Our Ref: SK/7887/jj

15 November, 2010

RE: PART 3A PROPOSED MIXED USE DEVELOPMENT
7 RAILWAY STREET, CHATSWOOD

title: Carparking Level B6, Floor Plan  
Carparking Level B7, Floor Plan

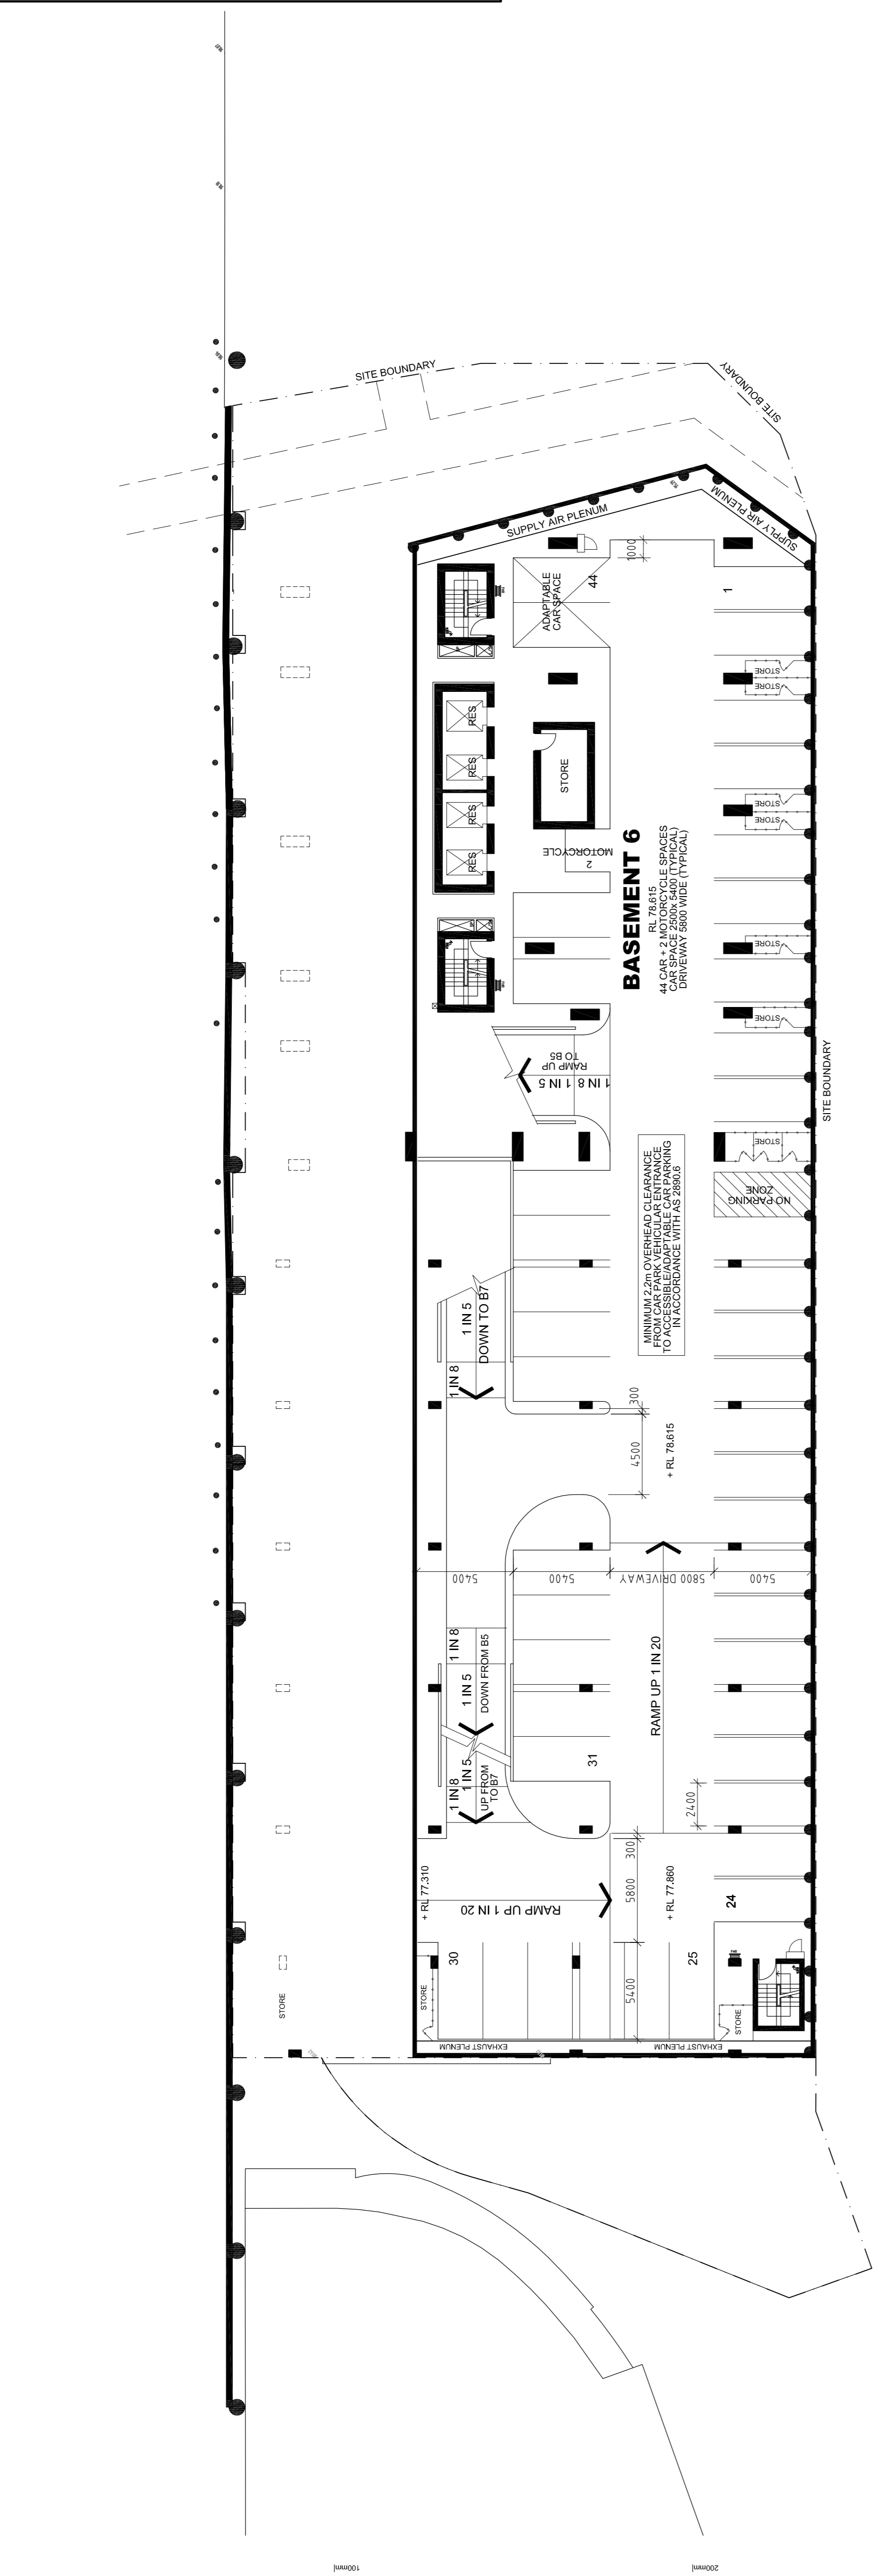
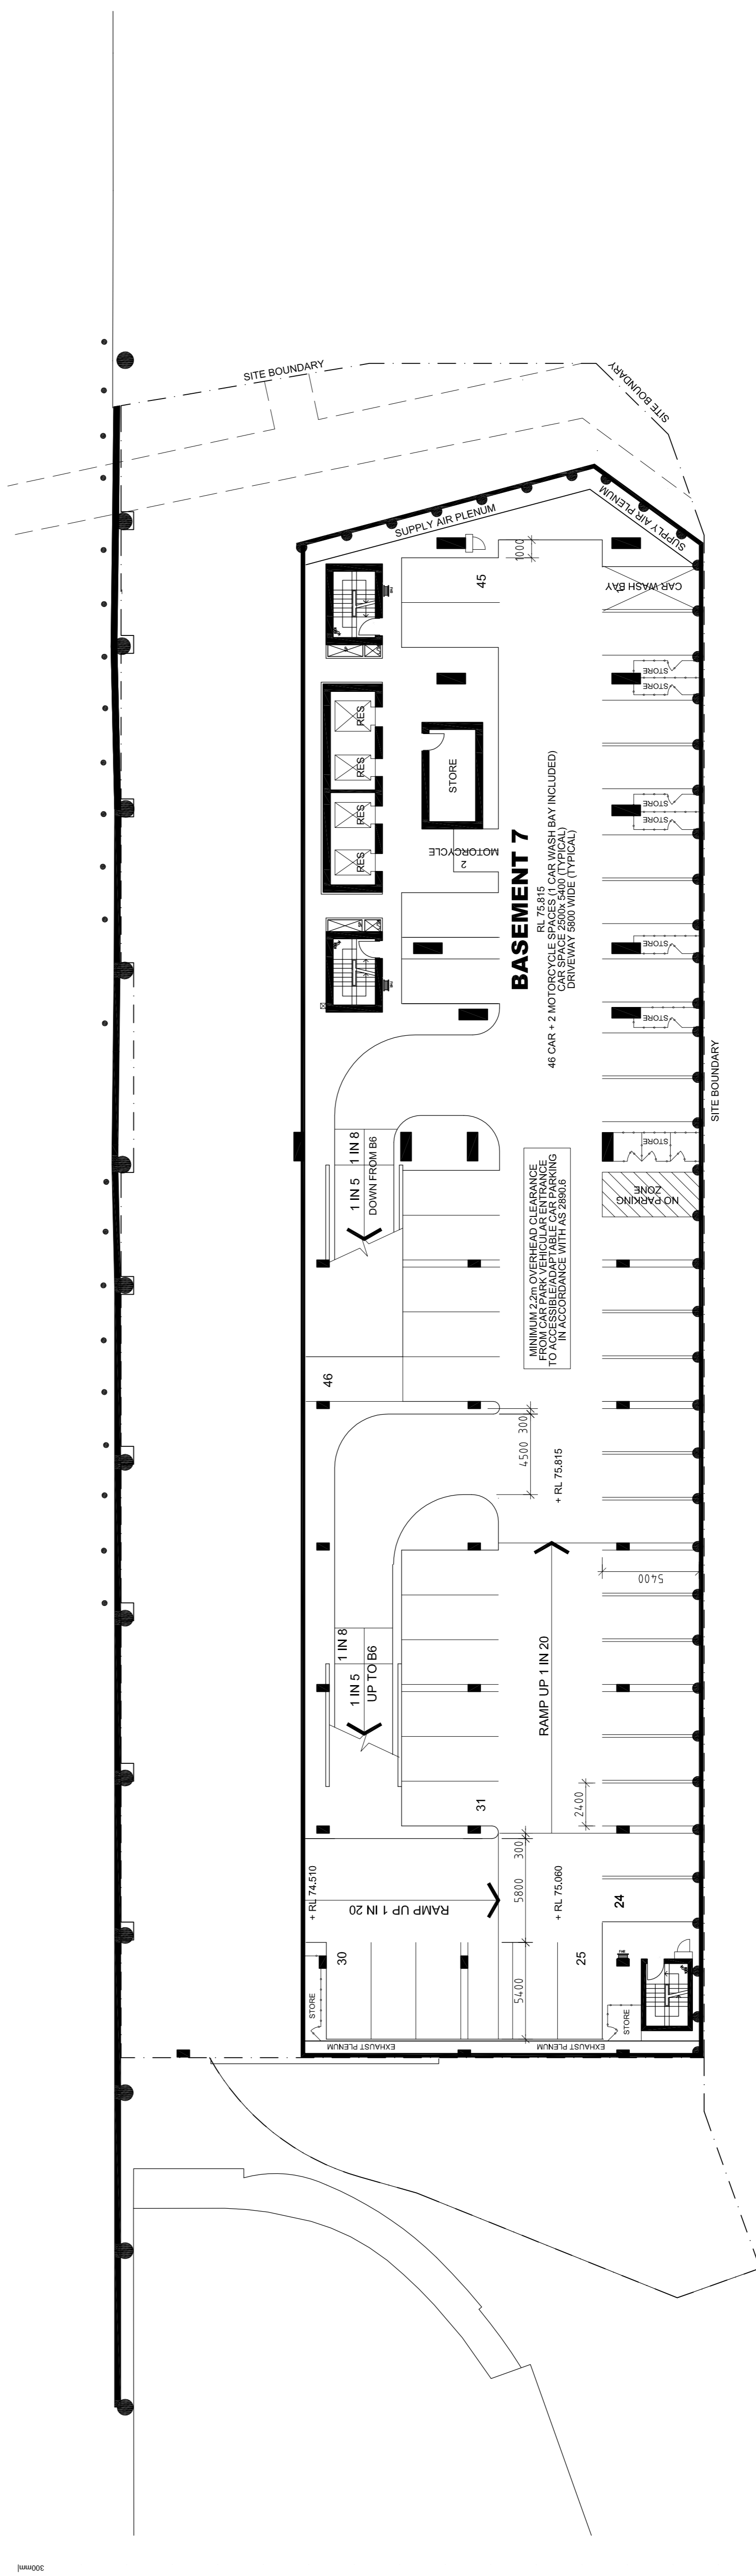
The on-site car parking provision on site is considered excessive given the accessibility to rail and bus services, and employment opportunities. To minimize traffic generation in the centre and to encourage use of public transport, the car parking provision should be reduced to a more appropriate level given the site's close proximity to the Chatswood Transport Interchange, and a justification for the revised car parking provision should be provided in the context of the broader locality.

The proposed allocation of car parking to different uses should be identified.

5. The access driveway, off-street parking and loading areas associated with the proposed development (including driveways, grades, parking aisle widths & aisle lengths, turning paths, sight distance requirements, and parking bay dimensions) shall be re-designed to be in accordance with AS2890.1-2004 and AS2890.2-2002 for heavy vehicles.

4. As previously discussed, it is proposed to reduce on-site parking for the proposed development. In its letter dated 17 September 2010, Council suggests the following maximum parking rates:-
- ☐ Residential
 - one space per unit;
 - one space per seven units for visitors;
 - ☐ Commercial
 - one space per 200m² GFA;
 - ☐ Retail Shops
 - one space per shop/tenancy.
5. Application of the above rates results in a maximum provision of 363 spaces. The proposed provision of 332 spaces is in accordance with Council's suggested reduced parking requirement and is a significant reduction in on-site parking from the original project application.

7. It is proposed to provide one parking space per residential unit and share residential visitor parking with the commercial tenant spaces. Nine dedicated visitor parking spaces will be provided during the peak commercial periods. Outside these periods on-site commercial parking spaces (total of 33 spaces, including 9 dedicated visitor spaces plus 24 commercial spaces), would therefore be available for visitors to the development during evenings and on weekends. The shared use of parking spaces by the commercial uses and residential visitors is considered appropriate. Commercial and residential visitor spaces will be provided on basement level 1. Residential tenant spaces (295 spaces) will be provided on basement levels 2 to 6.

24. Parking bay dimensions will be provided a minimum of 2.4 metres wide by 5.4 metres long for residential and commercial tenants and 2.5 metres wide by 5.4 metres long for visitors. Parking spaces will be 0.3 metres wider for spaces located adjacent to structure. Access to parking spaces will be provided from a 5.8 to 6 metres wide two-way traffic aisle circulating through the various parking levels. Columns will be set back 0.75 metres from the front of spaces.

26. Access between the parking levels will be provided by a combination of ramped parking floors and two-way vehicular ramps, ramp grades, transitions, widths and height clearances will be provided in accordance with AS2890.1004.
